Subject: 2021/91239/W Revised Proposals for redevelopment of 410 & 412 Birkby Road, HD2 2DN

2021/91239/W Revised Proposals for redevelopment of 410 & 412 Birkby Road, HD2 2DN

Proposed Site Layout Plan

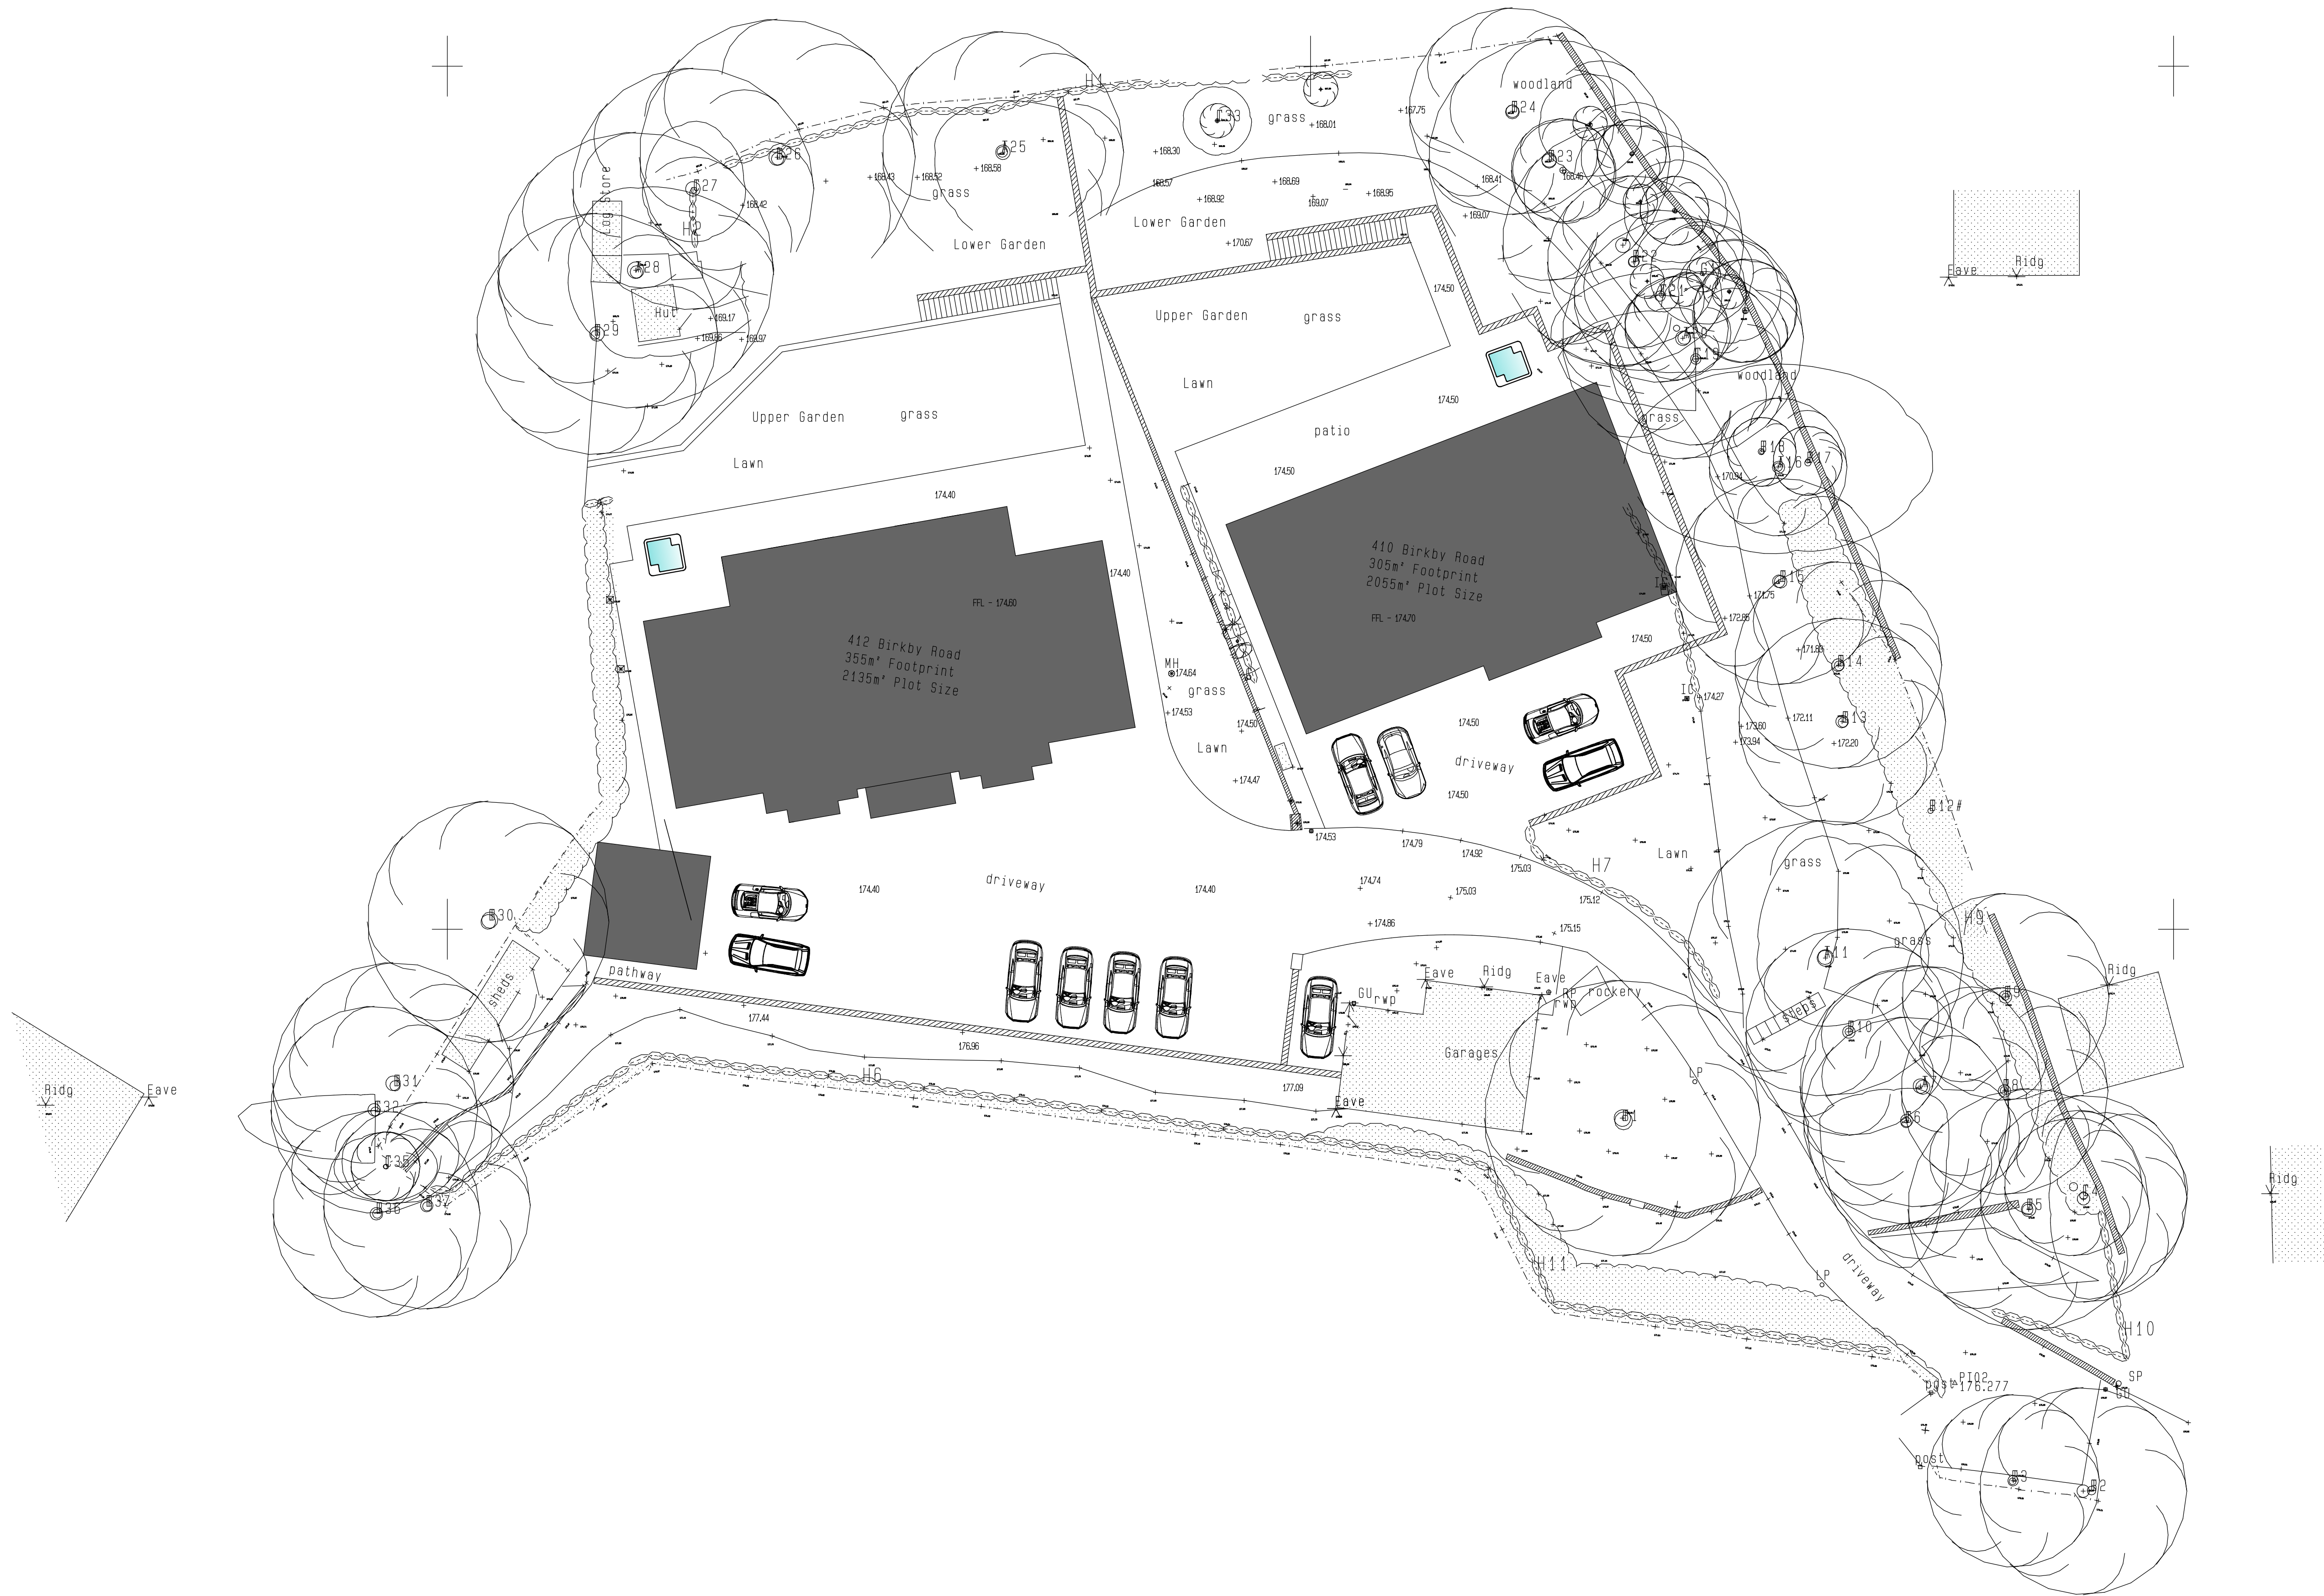
The changes principally involve moving the new house at 410 Birkby Road approximately 3 metres further from our property, along with a smaller shift in the location of the new house at 412 Birkby Road. We understand there has also been a minor reduction in the proposed size of the properties and of the associated hard landscaping.

- Potential damage to significant trees currently subject to a woodland TPO. The marginally revised footprint would still require substantial construction works within the area covered by the TPO, inevitably resulting in damage to and the eventual death of these magnificent trees.

Front Elevation

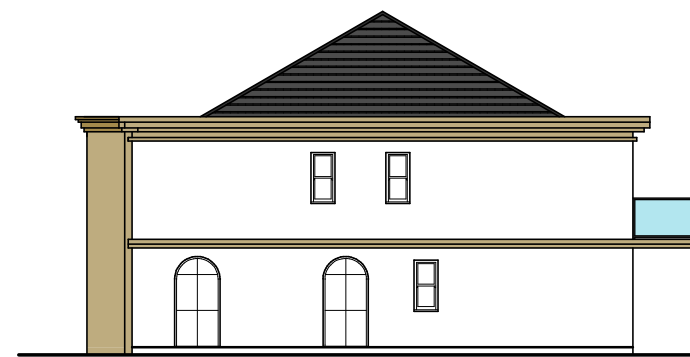
- The change from a dormer bungalow to a much higher two storey building and the inclusion of windows and substantial balconies directly overlooking our property directly contravene previous planning decisions about the site and remain fundamental concerns for us.
